2024/0188

Erection of 2x detached dwellings and associated works including formation of driveways and boundary treatments.

534 Carlton Road, Carlton, Barnsley, S71 3JE

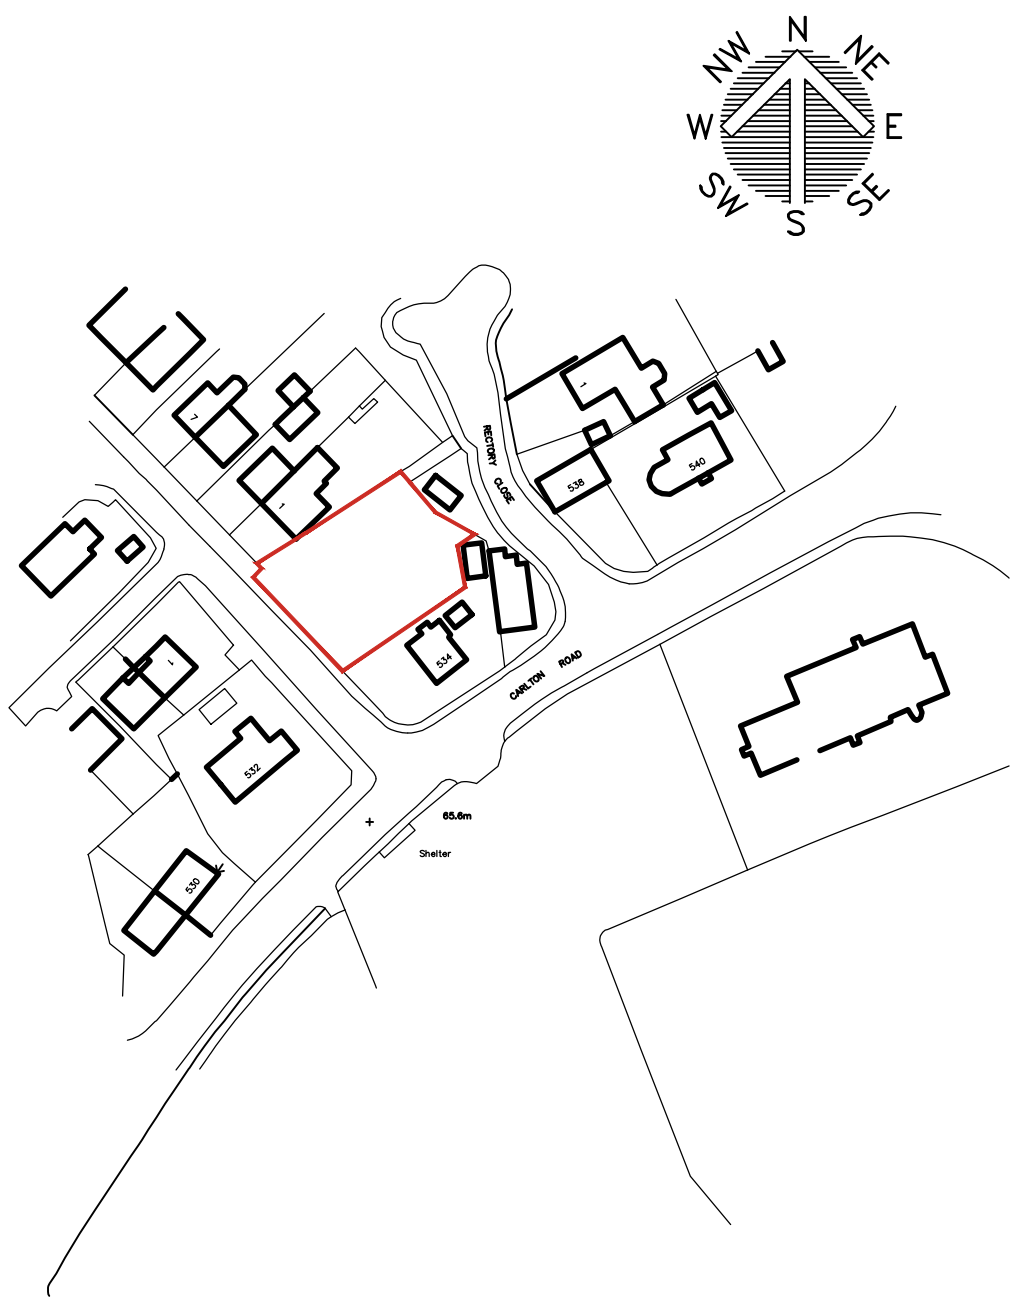
The siting of the proposed properties fails to follow the established build line as described above, and would encroach closer to Wood Lane. The principal elevation of Plot 1 is sited 5.1m forward of the existing side elevation of No.534 Carlton Road, whilst Plot 2 sits 2.1m forward of No.1 Wood Lane. The siting of the proposed dwellings harmfully disrupts the existing build line, making the development appear alien within the street scene and detracting from the appearance of the site. The failure to follow the building line is mentioned in the letters of objection received from neighbours and is demonstrated on the plan below, with the yellow line indicating the established build line:

The Design of Housing Development SPD (section 4.5) states that proposed blank elevations should be at least 12metres from original habitable room windows. In this instance, the separation distance between the rear elevation of No.534 Carlton Road and the proposed side elevation of Plot 1 is 4.35m, significantly short of the SPD requirement. This would result in the occupants of the habitable rooms having an extremely oppressive and dominating outlook onto a blank wall.

The separation distance between the existing rear elevation and the side elevation of the proposed Plot 1 is discordant with the SPD guidance, being significantly below the required distance. The development would therefore introduce substantial harm upon the existing residents of No.534 Carlton Road by virtue of an oppressive and dominating outlook from the rear elevation windows. The proposal is discordant with Local Plan Policy POLL1 and Policy GD1 as well as the Design of Housing Development SPD.

Proposed Front Elevation
scale 1:100

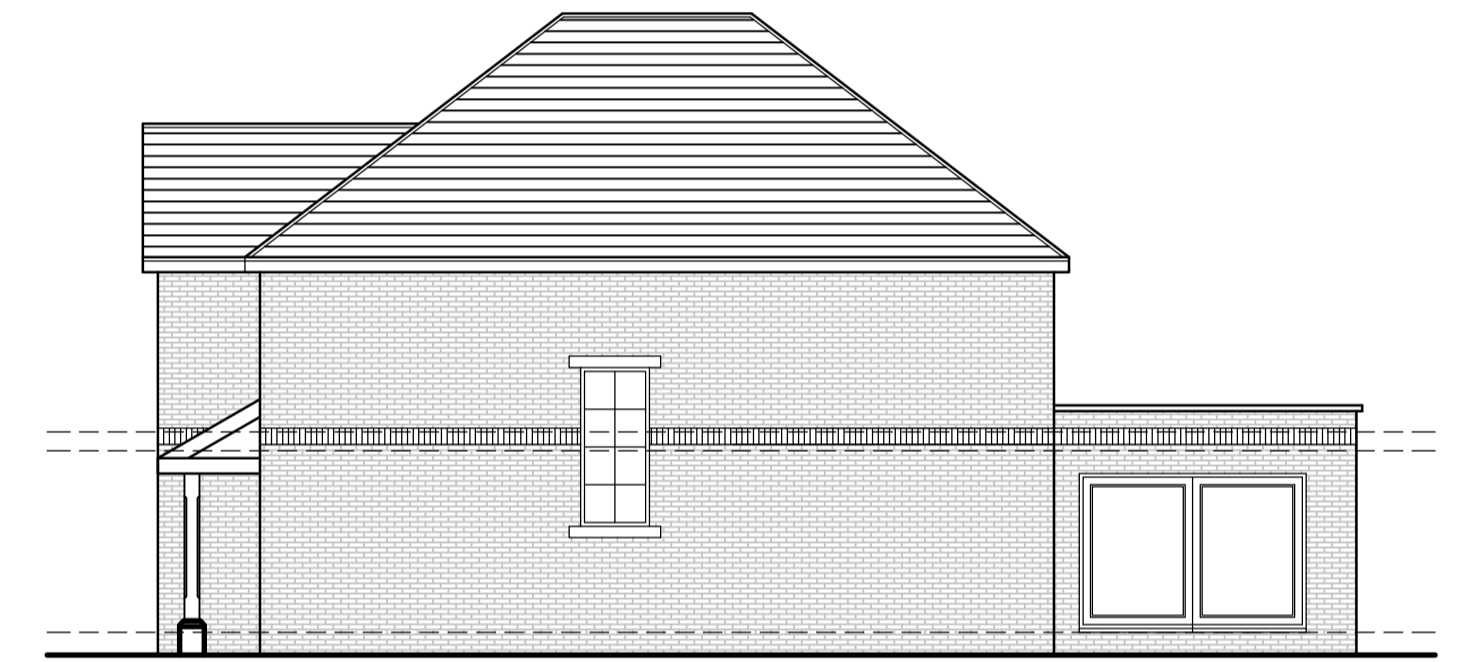
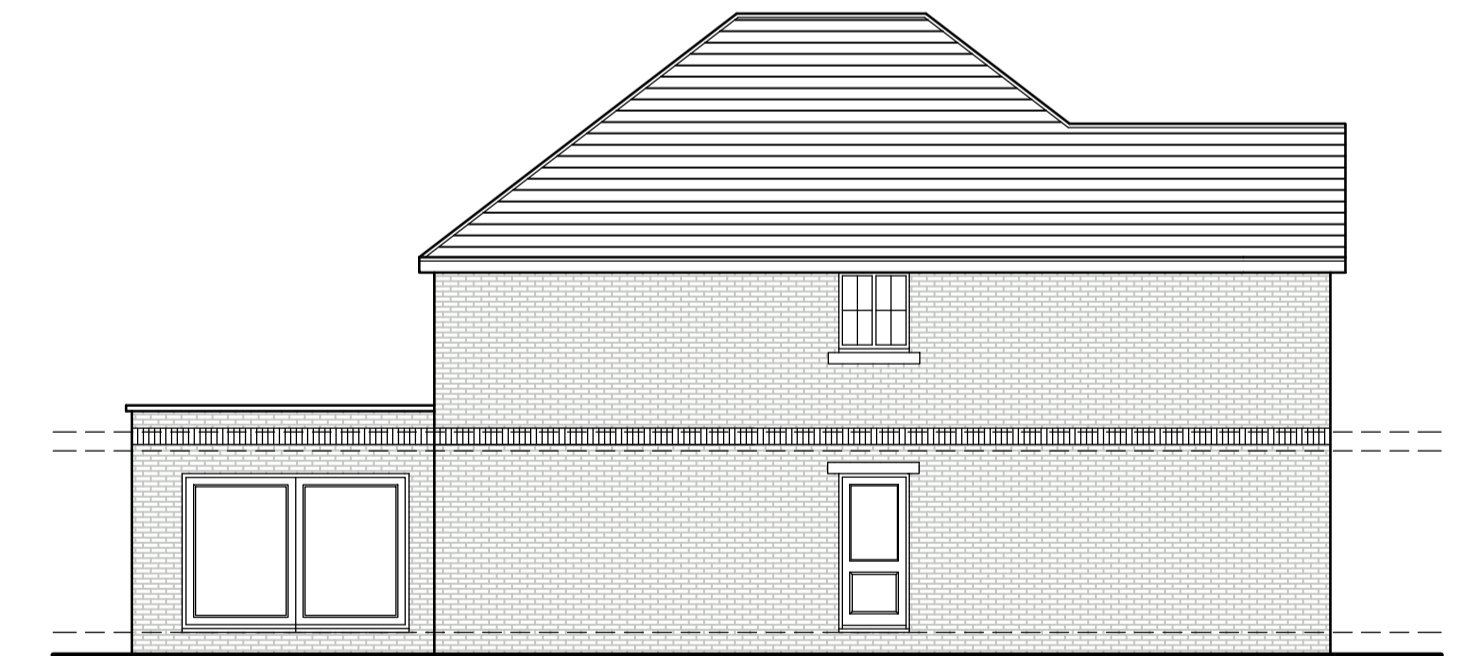
The overall scale and form of the dwellings adds to the harm which the development would introduce upon the street scene. The footprint of the proposed dwelling housetype is 107sqm which is substantially larger than the adjacent properties. No.534 Carlton Road has a footprint of 41sqm and No.1 Wood Lane has a footprint of circa 51sqm, both less than half the size of the proposed housetype. The substantially larger footprint of the proposed dwellings would dominate the appearance of the site and appear as an overdevelopment, as mentioned in the letters of objection.

Although the height of the proposed dwelling is similar to the adjacent properties, the overall massing and appearance does not reflect the local characteristics. The use of front facing gables and pitched roofs is not representative of the neighbouring dwellings. The depth/projection of the dwellings also disrupts the established build pattern, with the dwellings having a depth of 15.9m.
